From: Nigel Locke [REDACTED]
Sent: 10 April 2019 13:49
To: Simon Davis <Simon.Davis@arun.gov.uk>
Subject: Re: FP/64/19/PL Mow Cottage

[REDACTED]
Subject: FP/64/19/PL Mow Cottage

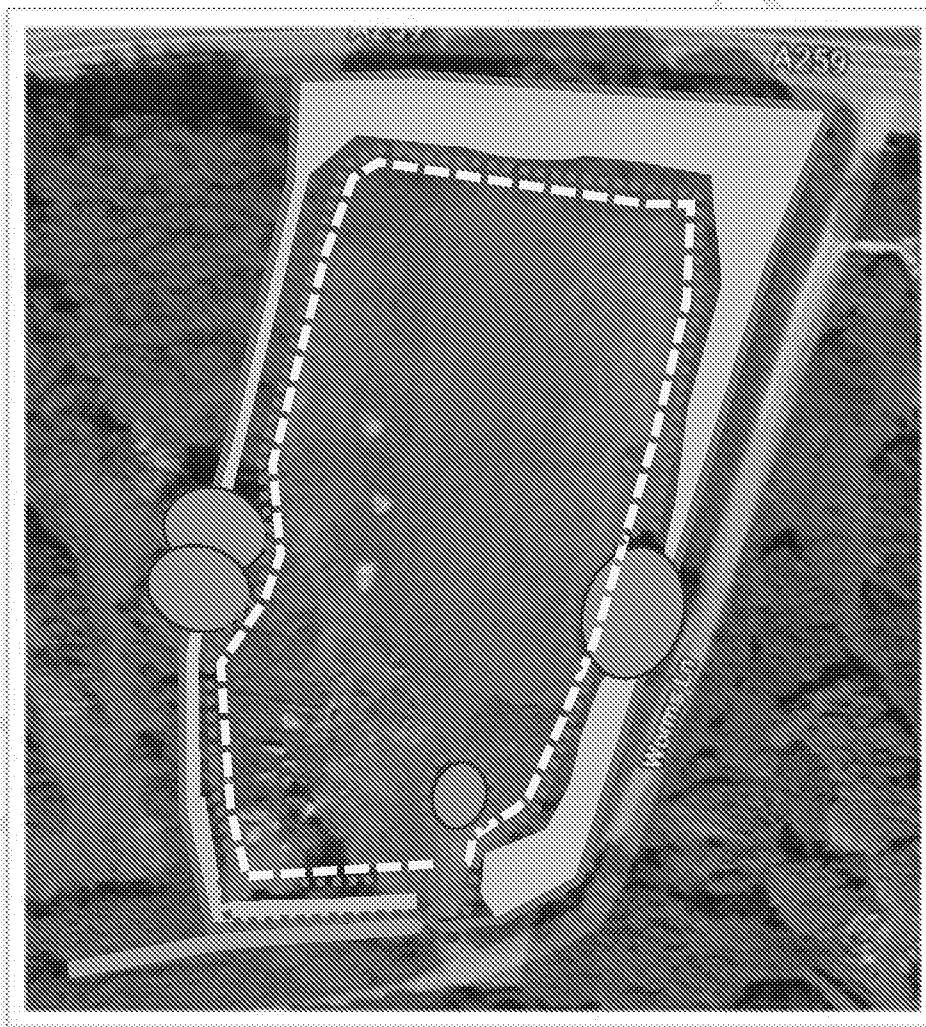
Can you arrange for the GCN surveys to be carried out as we will need to have these before determination. Please also note the comments in respect of water voles and dormice. If it is not possible to ensure the appropriate buffer zones, then species specific surveys may also be required. Finally, could the mitigation plan in the ecology report be updated to show the location of a wildlife pond.
